GBP 2,5 - 1
116 GARY WATSON POINT
COLORADO SPRINGS, CO 80915
EL PASO COUNTY, COLORADO

Site Development Plan_V1.pdf Markup Summary

PCD File No. PPR2031

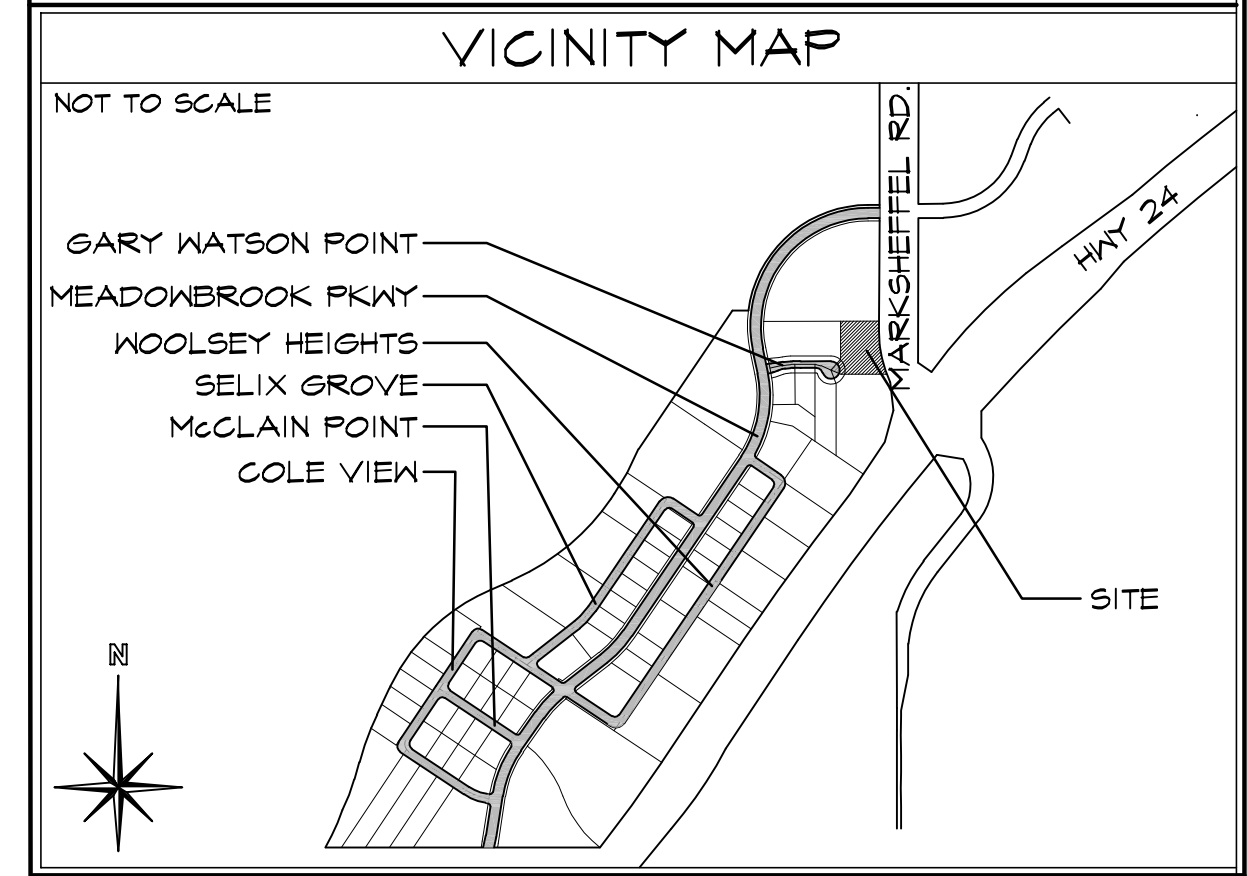
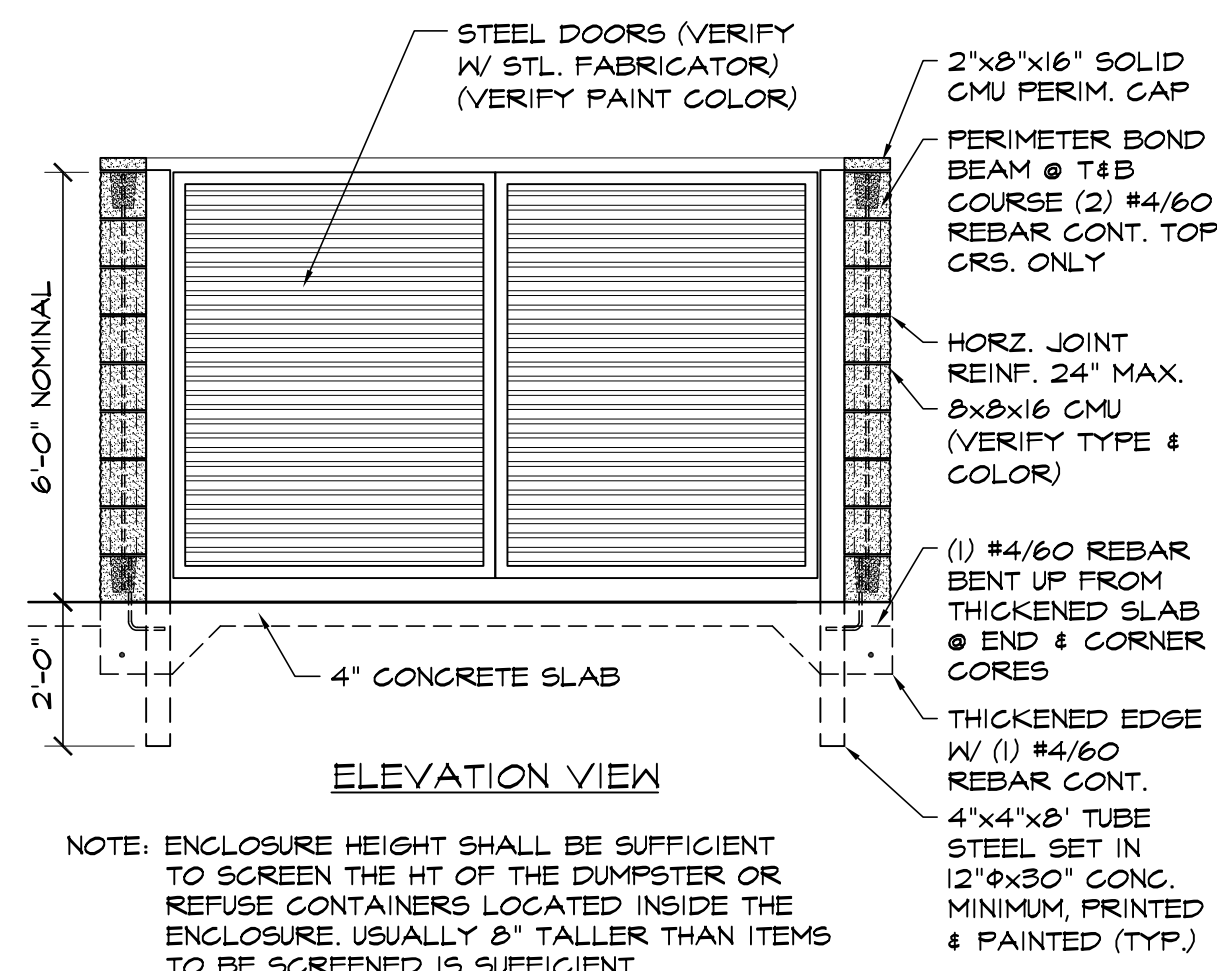
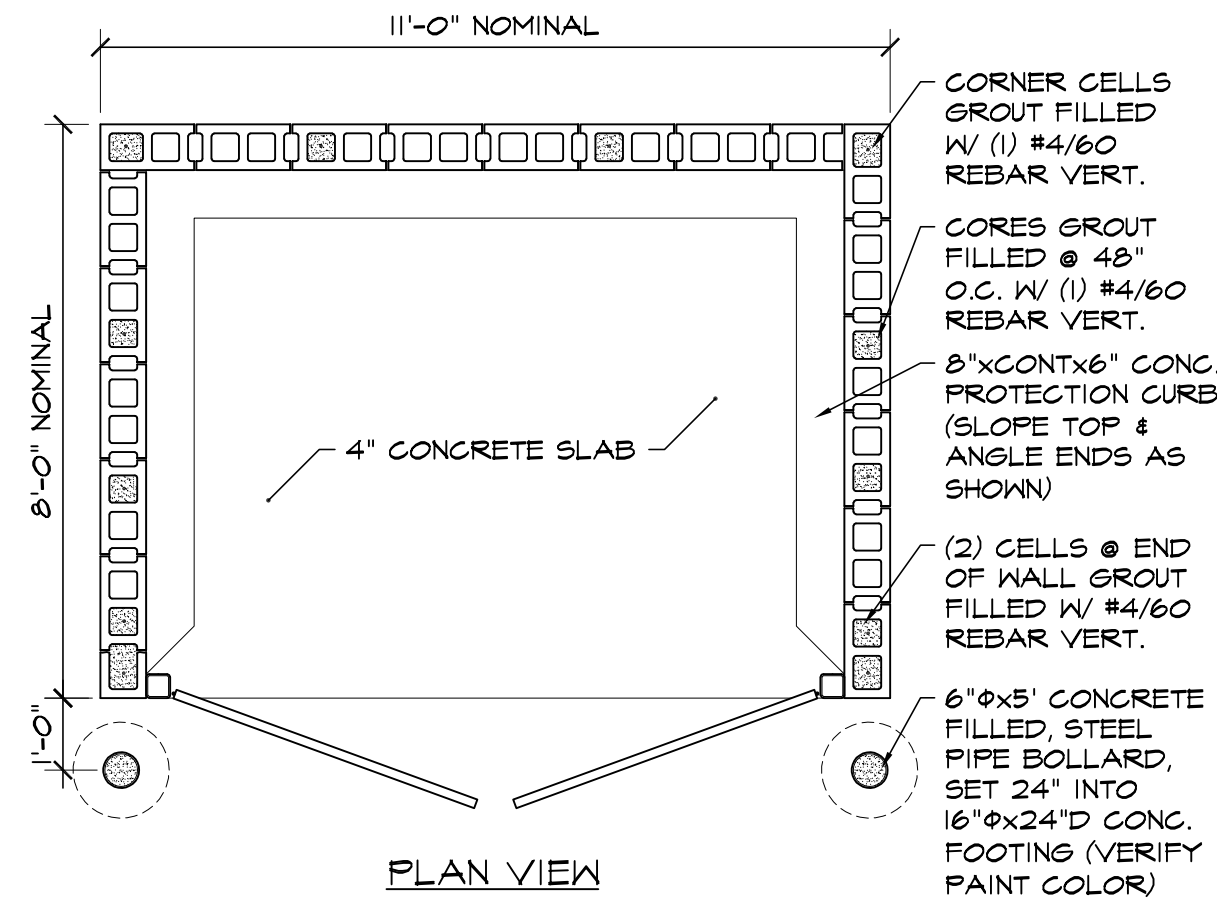
Show easements granted to Mountain View Electric as referenced in Title Commitment Exceptions Items 12 and 20

Parking should be open to everyone that may go to the site; if there is going to be outside storage, then it needs to be identified and will need to comply with additional standards (screening, etc.) and use approval process.

Please add ADA route as required by El Paso County Code

Please identify what this is.

- 1) Show existing and proposed topography.
- 2) Show the location of all existing and proposed utilities on the site or in the adjacent ROW.

to include all easements.
